Proposed Development

The proposal is for the removal of the low-pitched roof over the rear extension to be replaced with a flat roof terrace. The terrace will be bound by a glass balustrade partly obscured. Access to the terrace will be by the erection of an external staircase.

Recommendation

Approve with conditions.

Proposed Plans

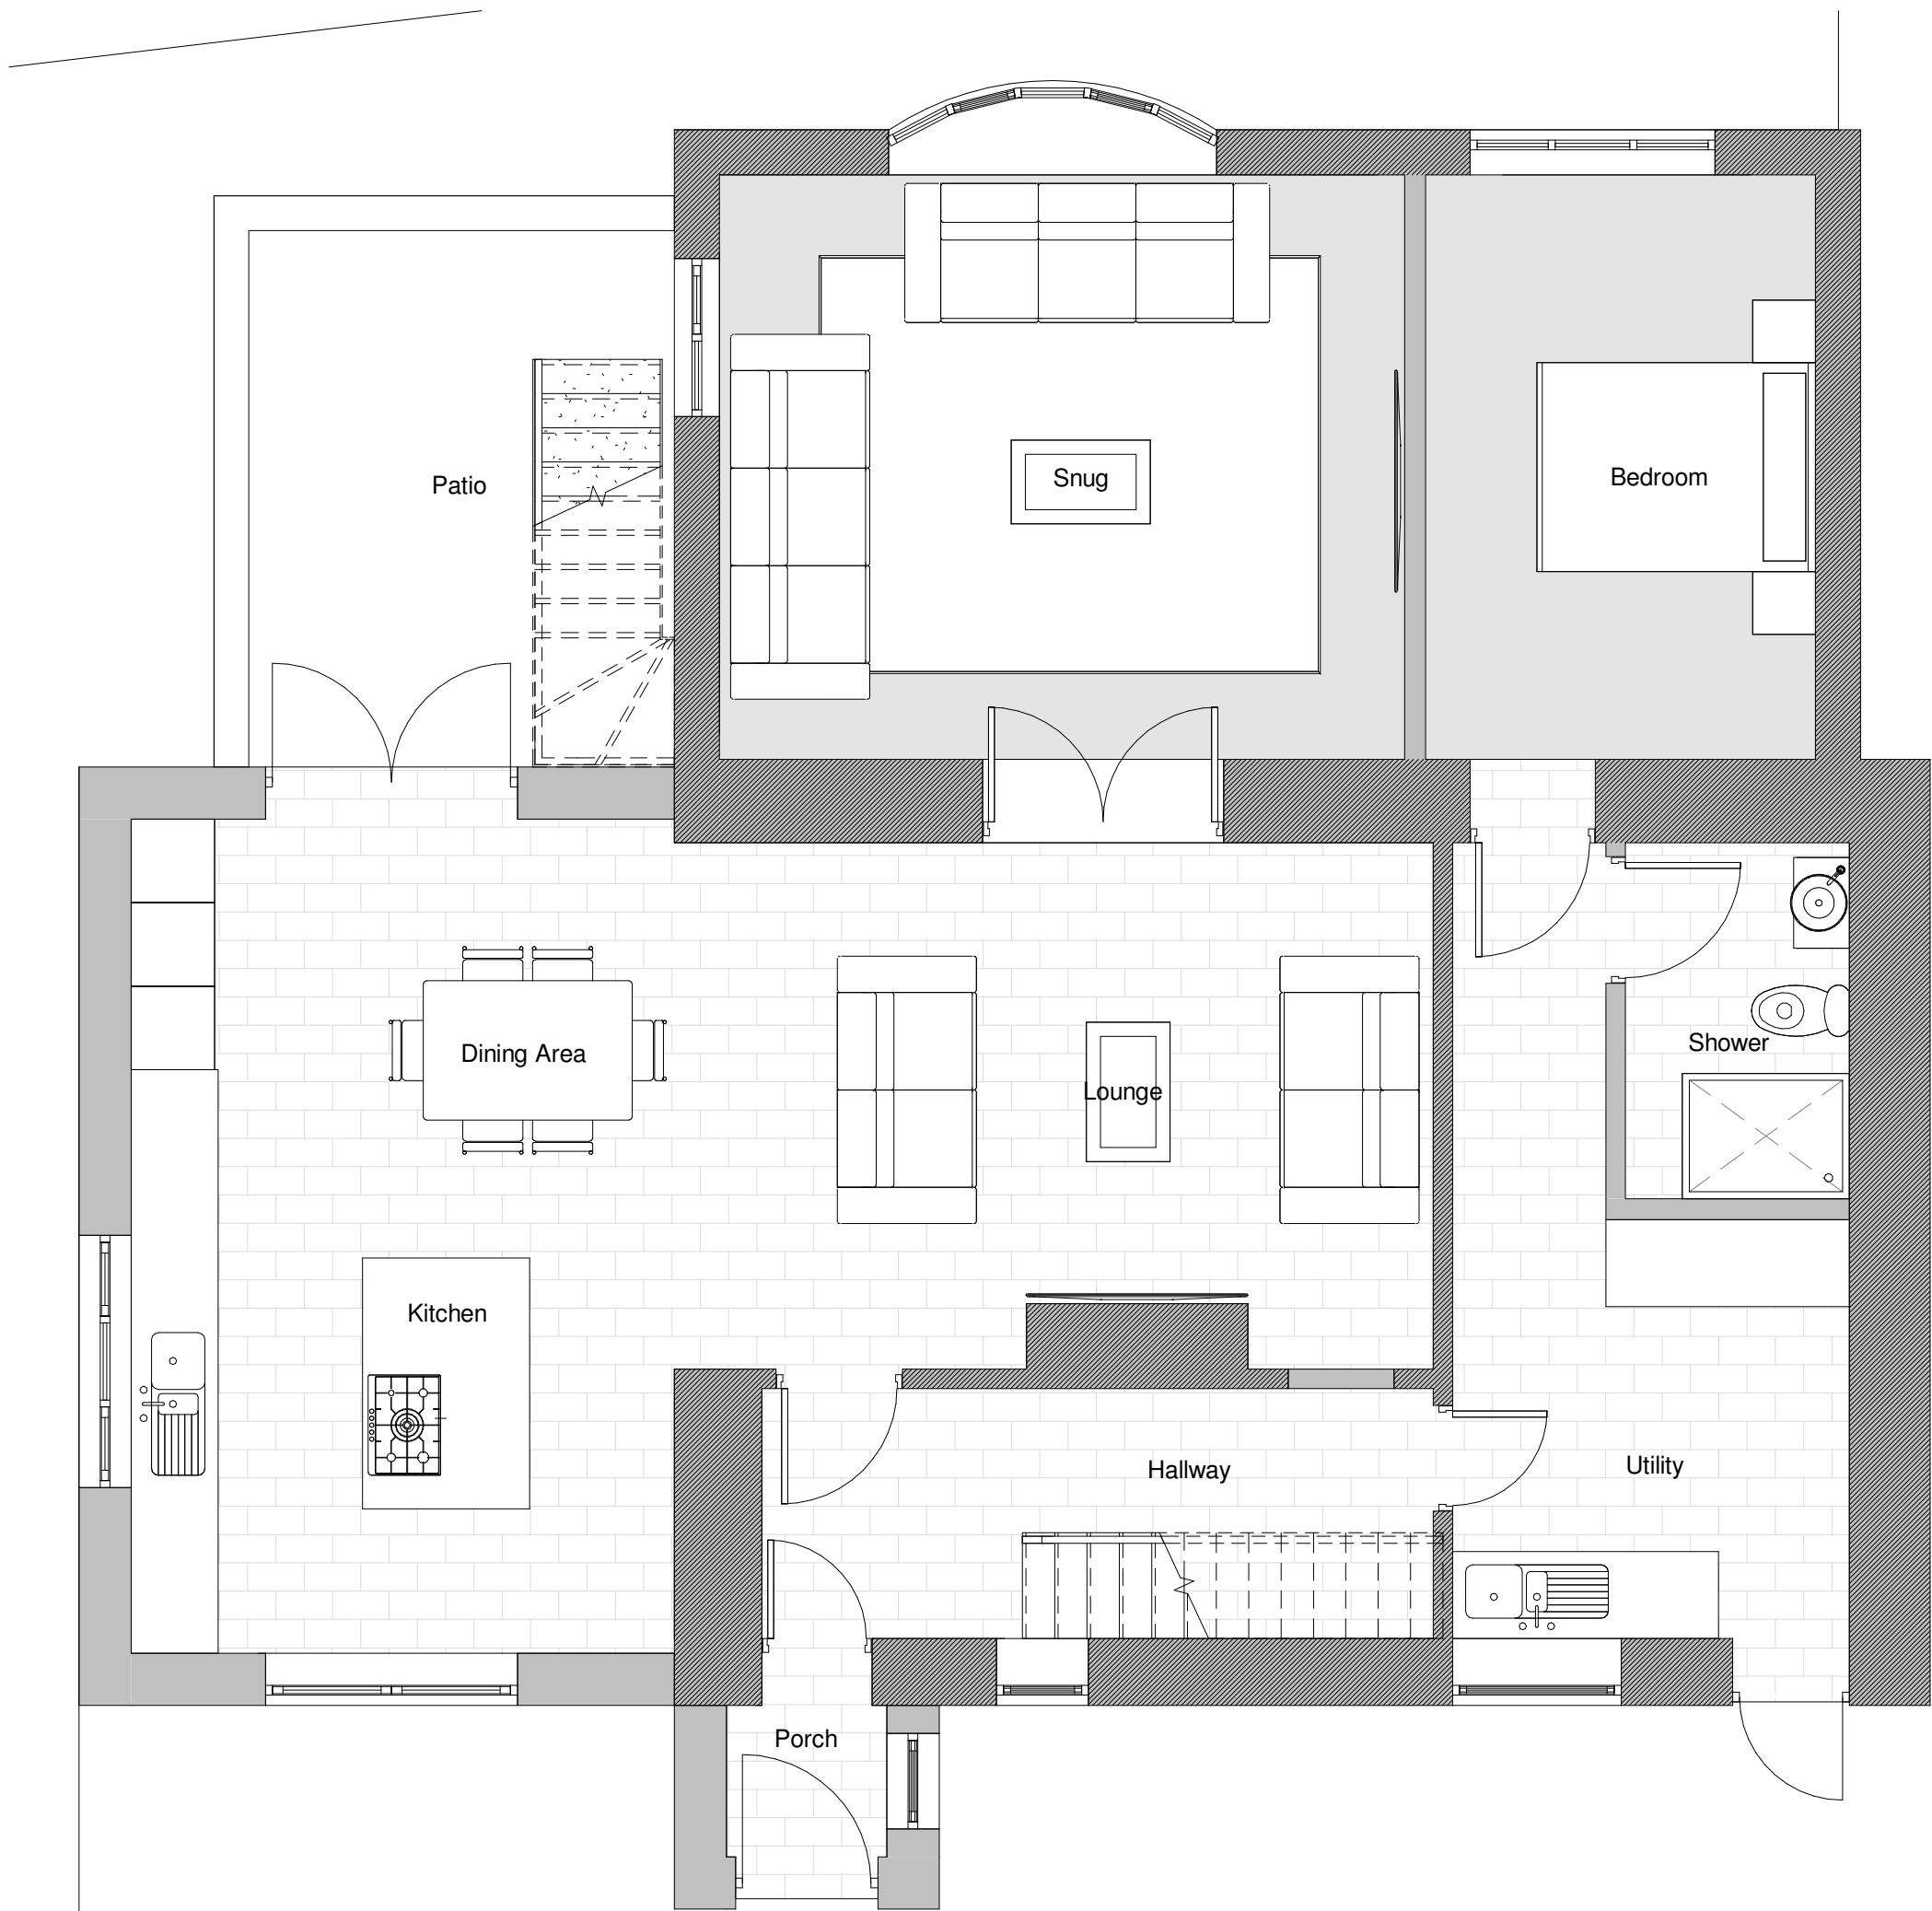
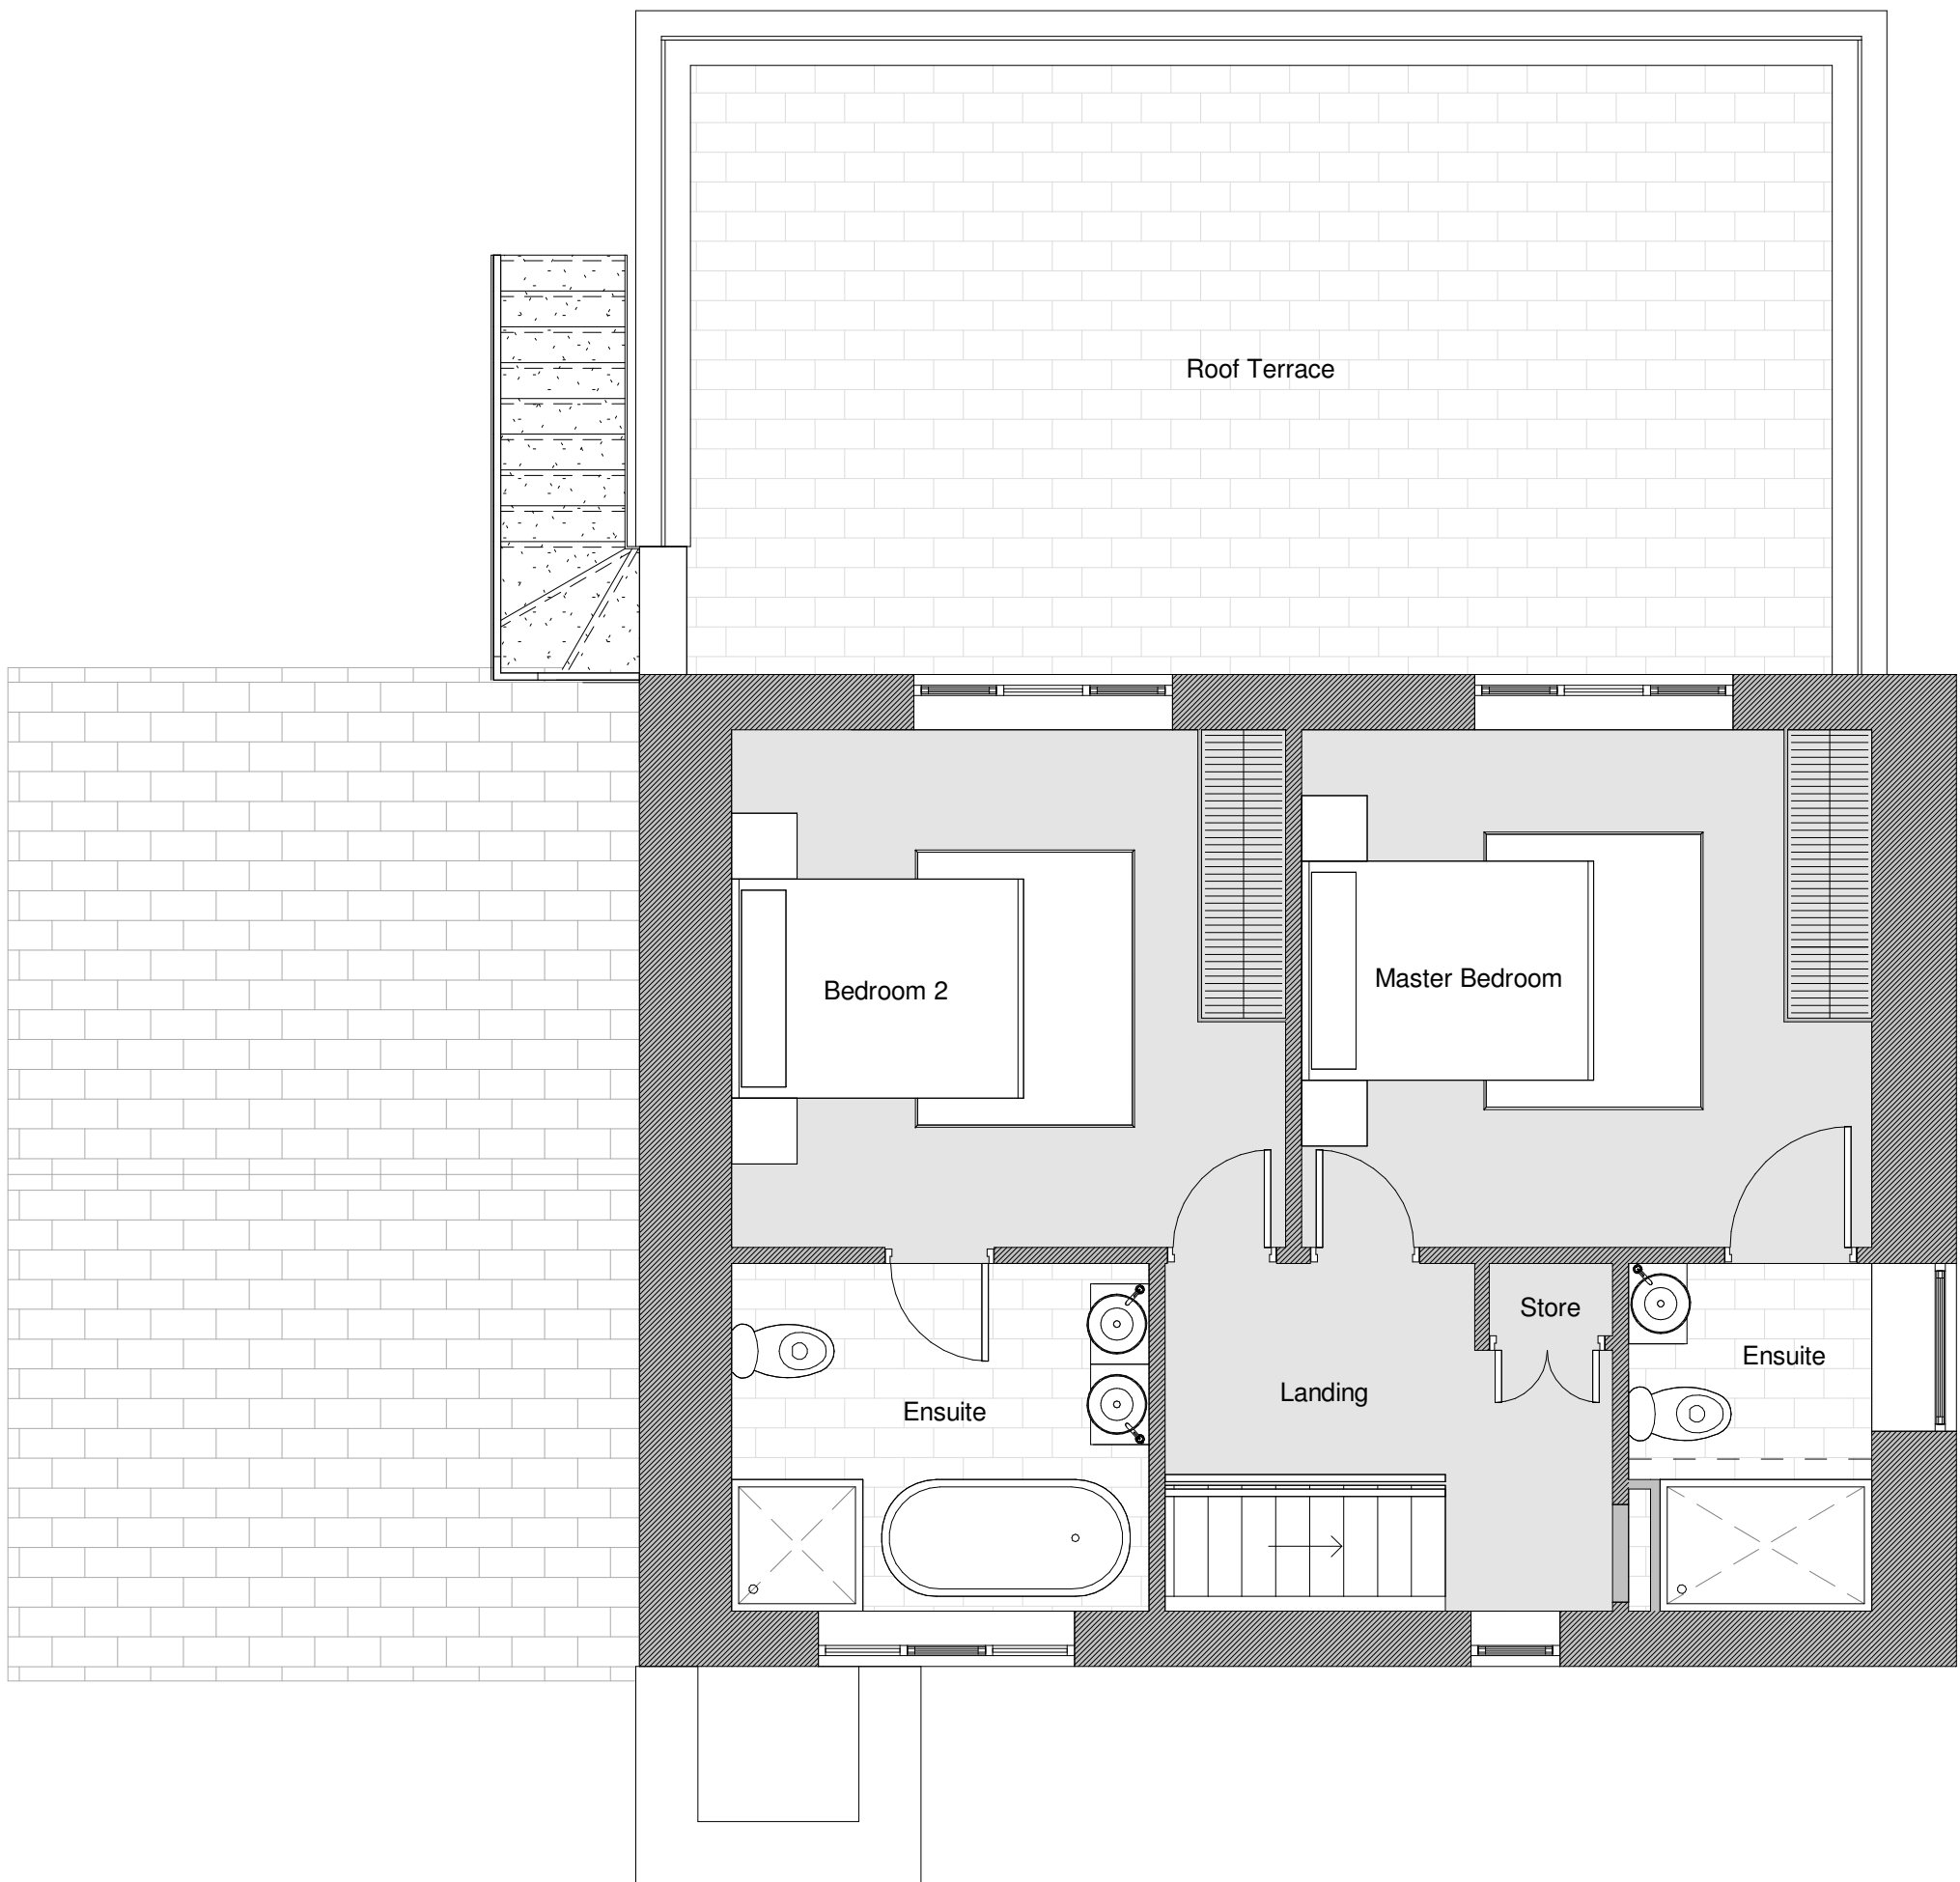
The formation of the external terrace will be located on top of the existing rear extension and therefore is not expected to impact the openness of the Green Belt. It can be argued that although the staircase will result in another structure which will have an impact when viewed collectively, is small scale compared to what could be erected within the realms of permitted development and is therefore in this instance acceptable.
